PUBLIC SUBMISSIONS

Winter Solstice, June 21, 12 Noon

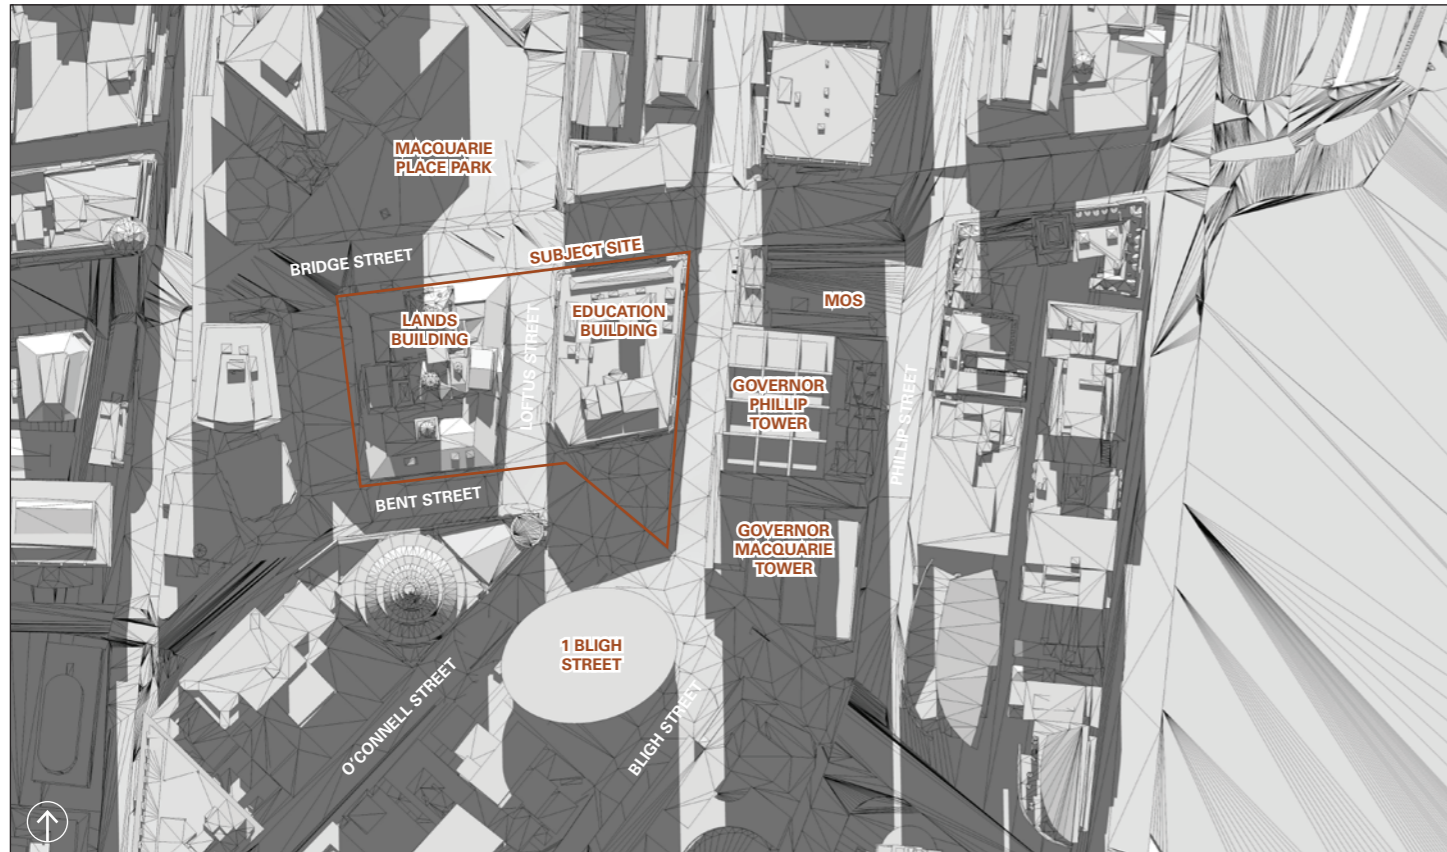
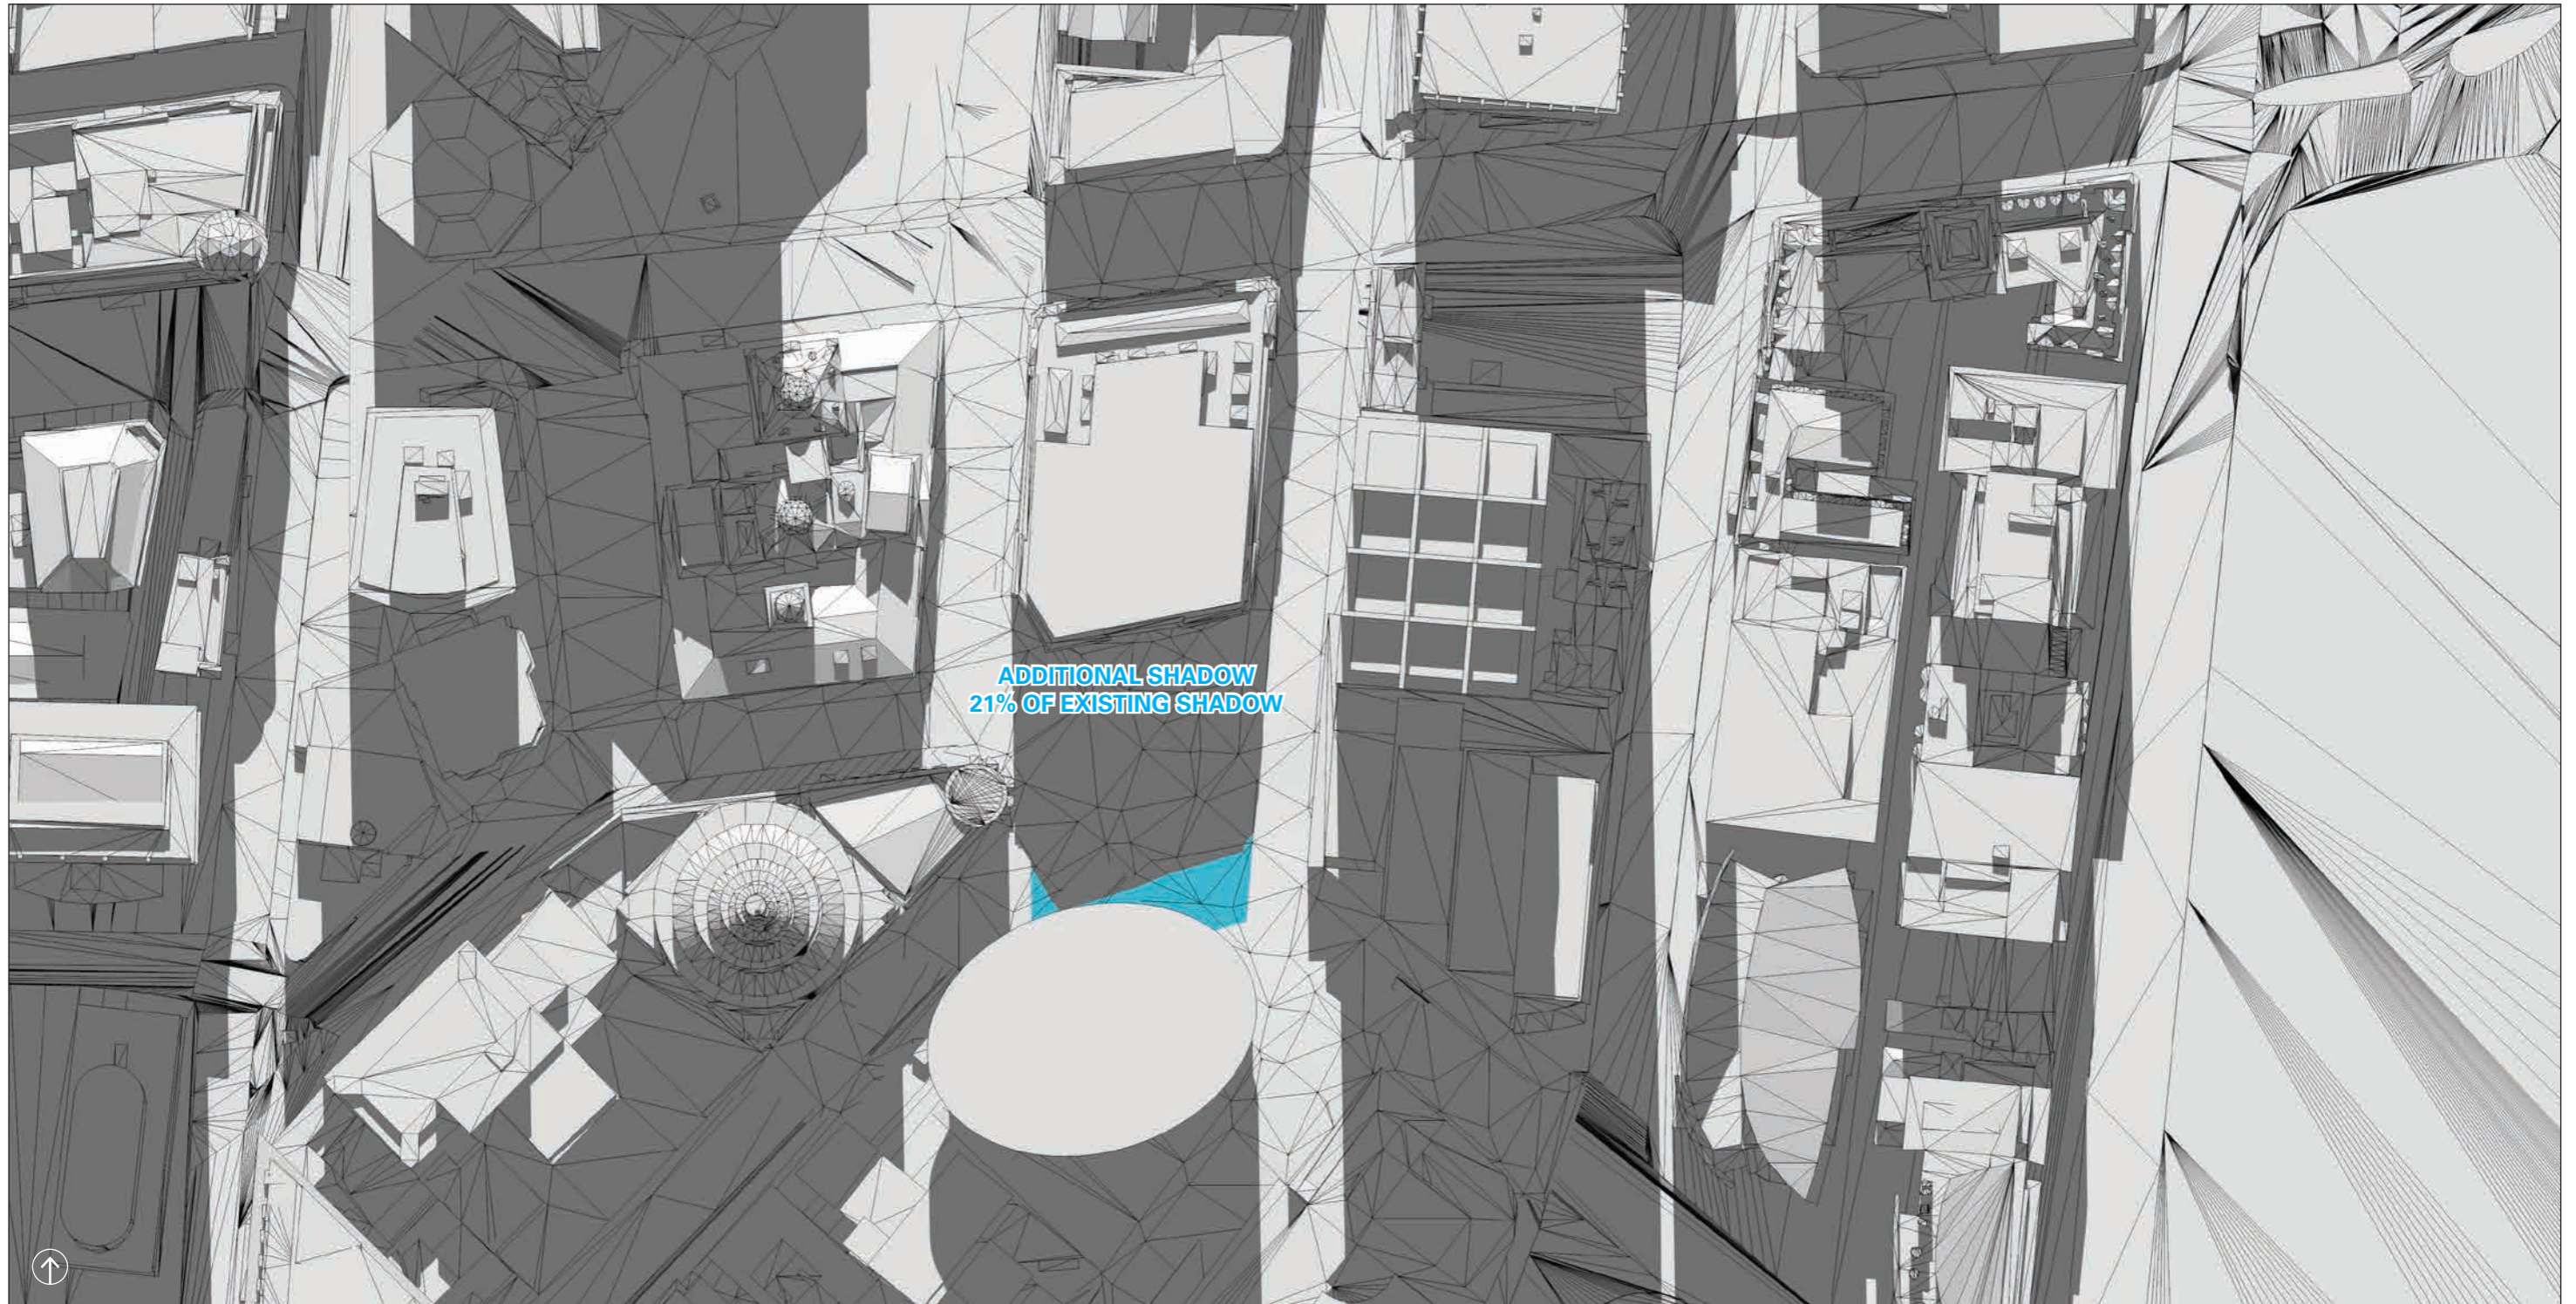
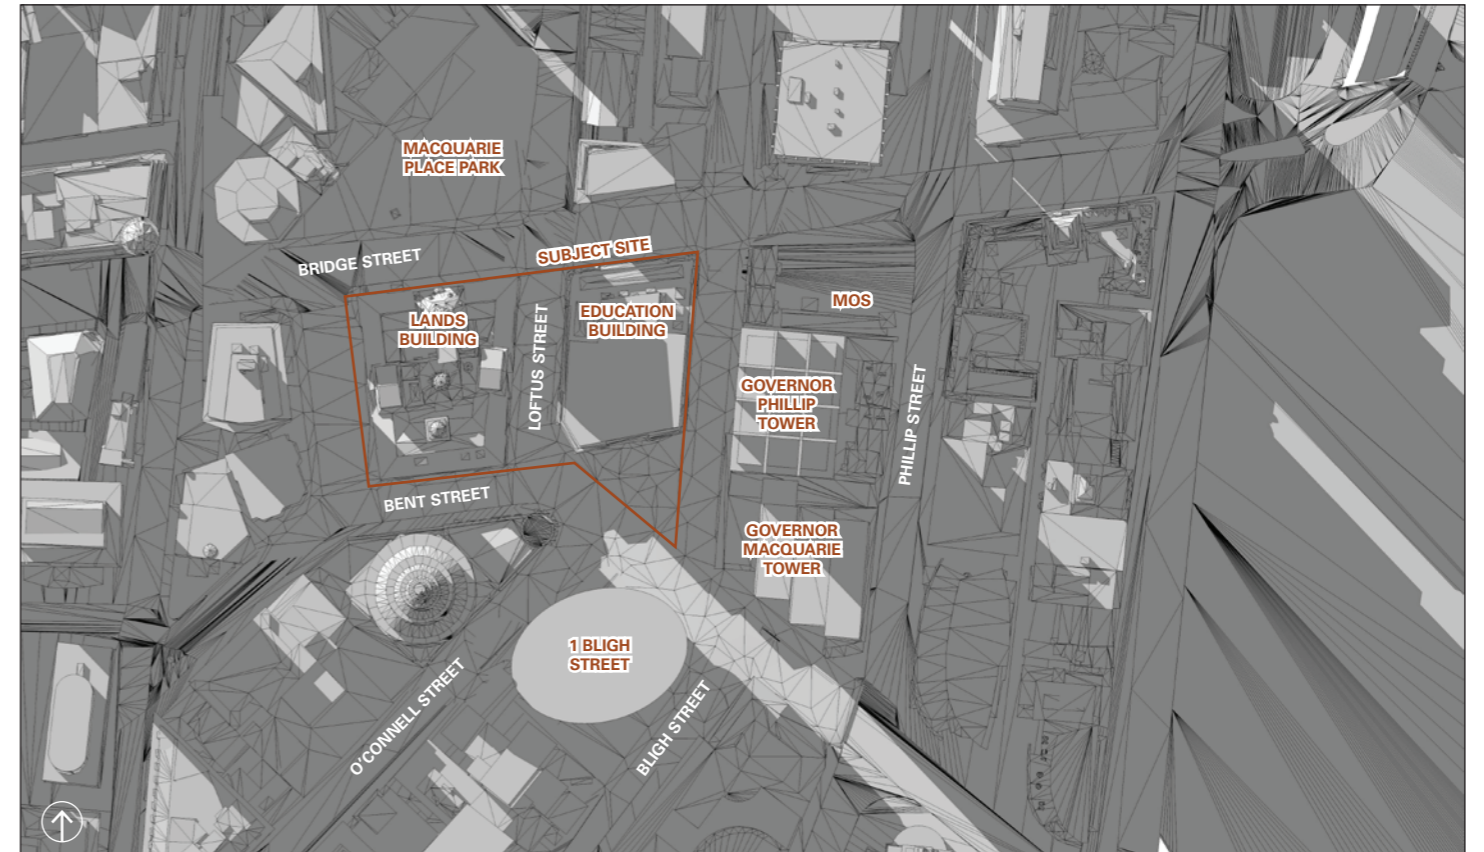
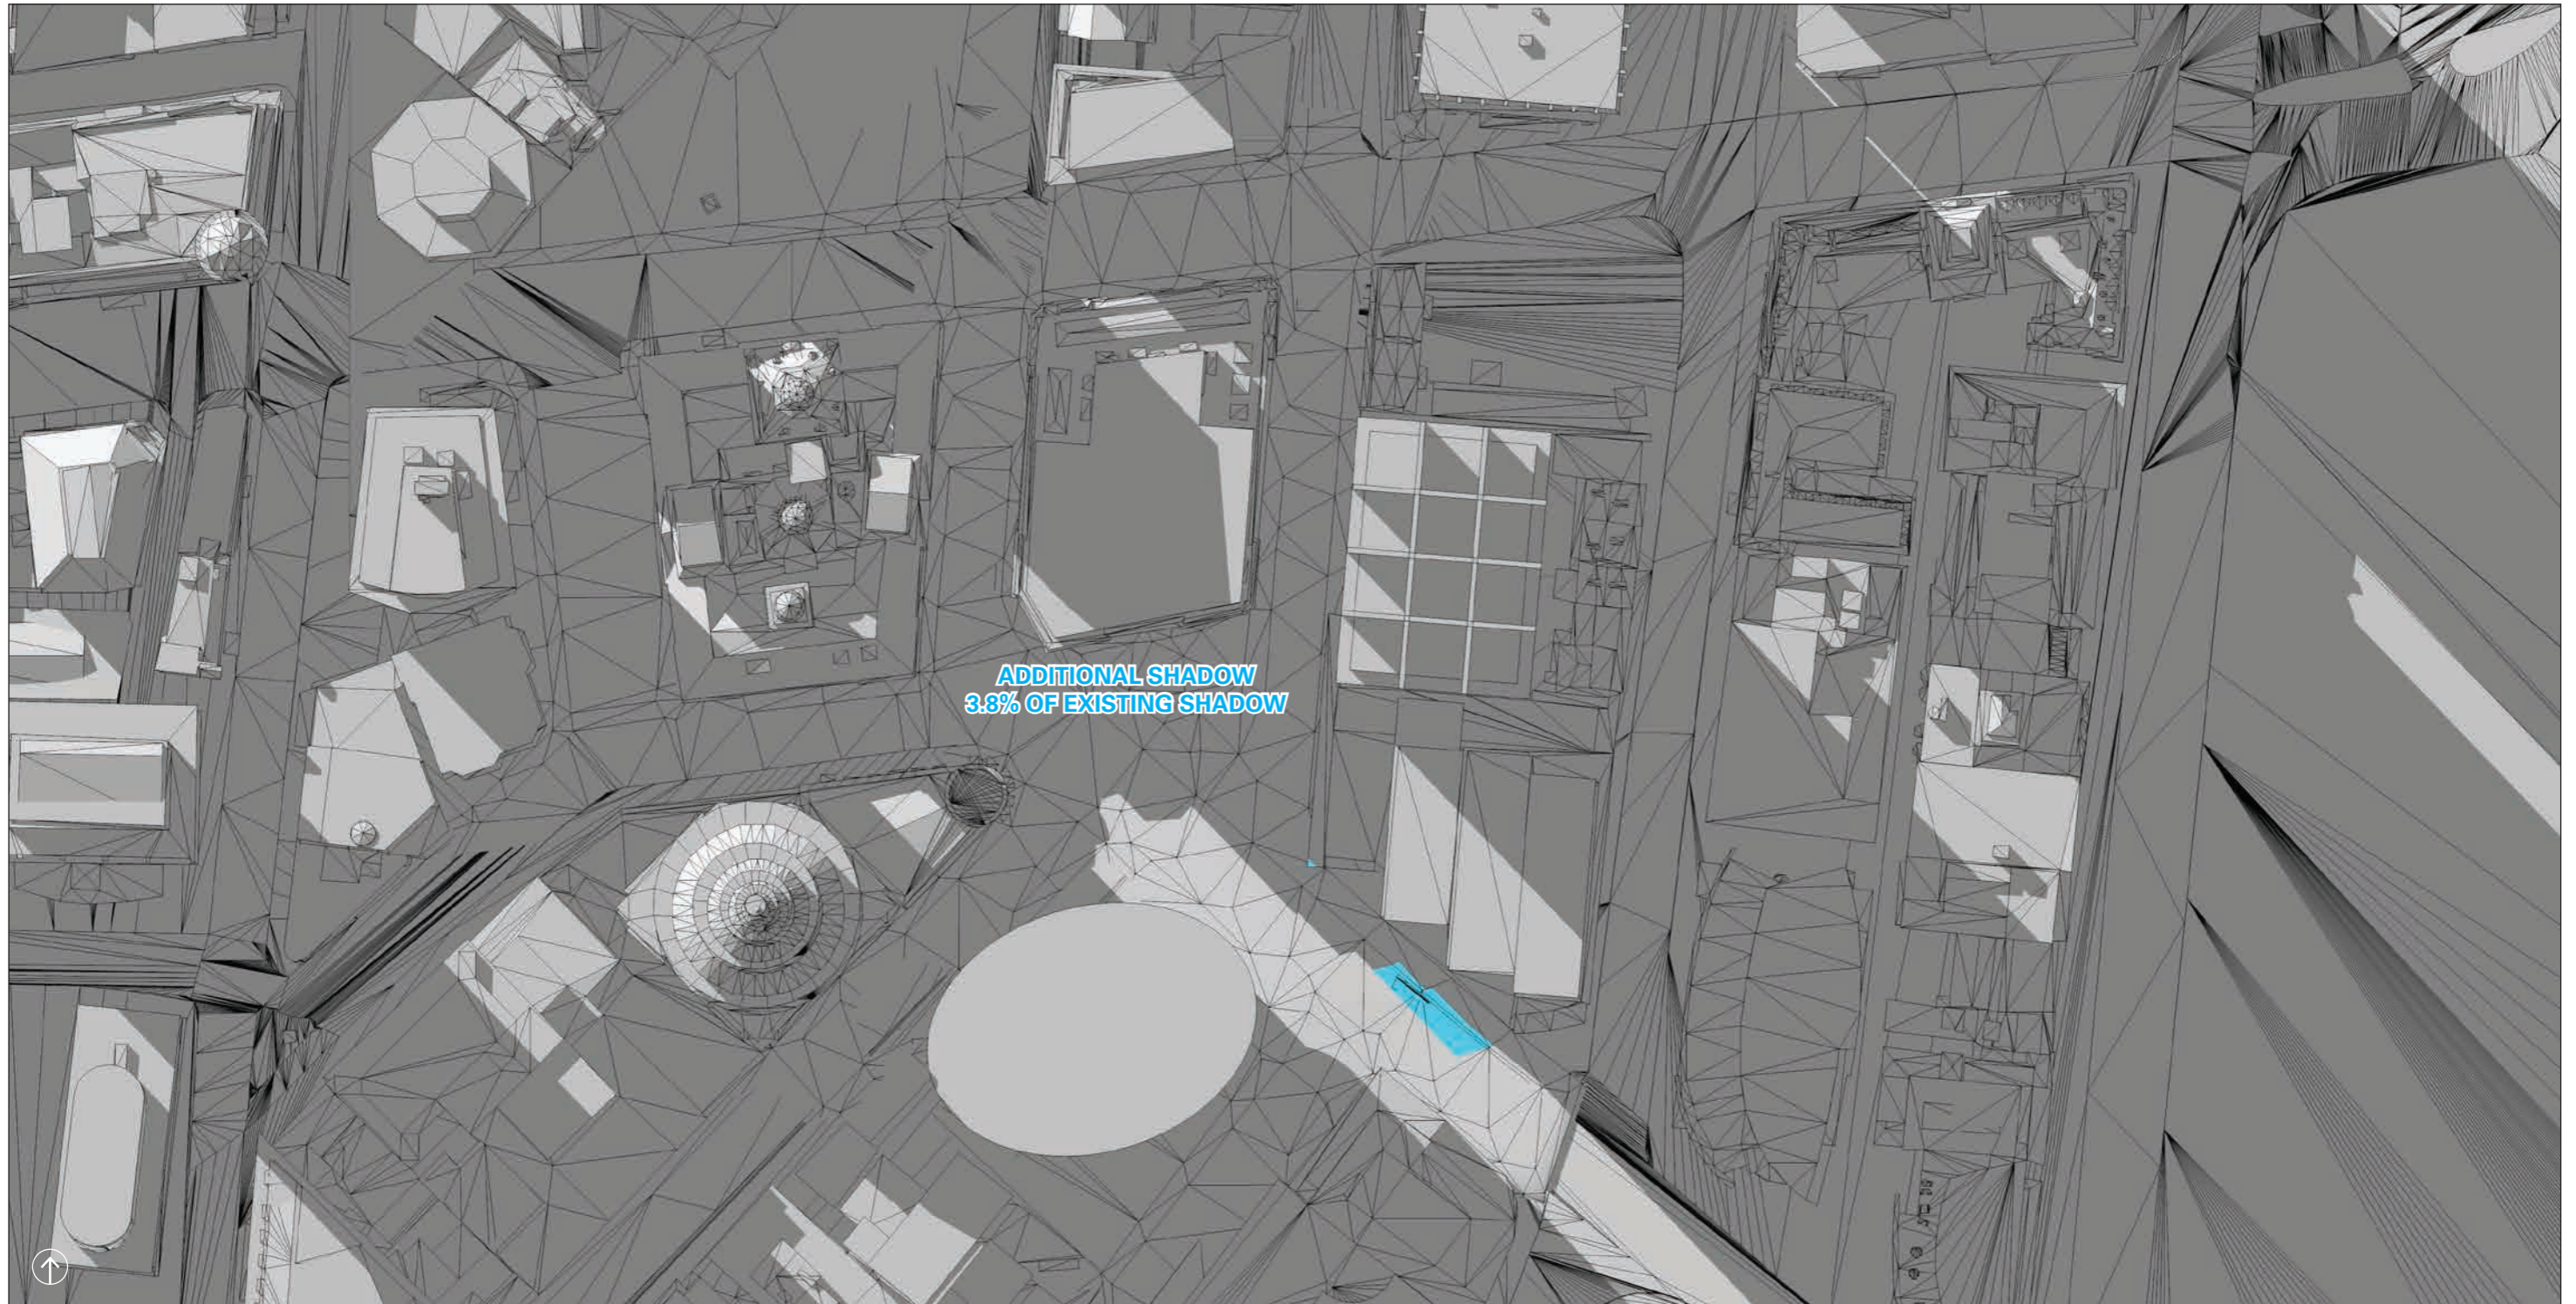
| <p>HEIGHT/OVERSHADOWING</p> <p>Increase in overshadowing</p> <p>Height increase is unacceptable when viewed from adjoining streets (should be setback)</p> <p>Rooftop additions should be setback</p> <p>The additional floors which create unacceptable shadow impacts on Farrer Place.</p> <p>The additional floors will create overshadowing on the Lands Building, which has not been addressed.</p> | <p>6</p> | <p>Clive Gunton</p> <p>Philip Drew</p> <p>WITHHELD</p> <p>WITHHELD</p> <p>John Freeman</p> <p>Peter Webber</p> | <p>See Section 2.1 of the Response to Submissions (RTS).</p> |
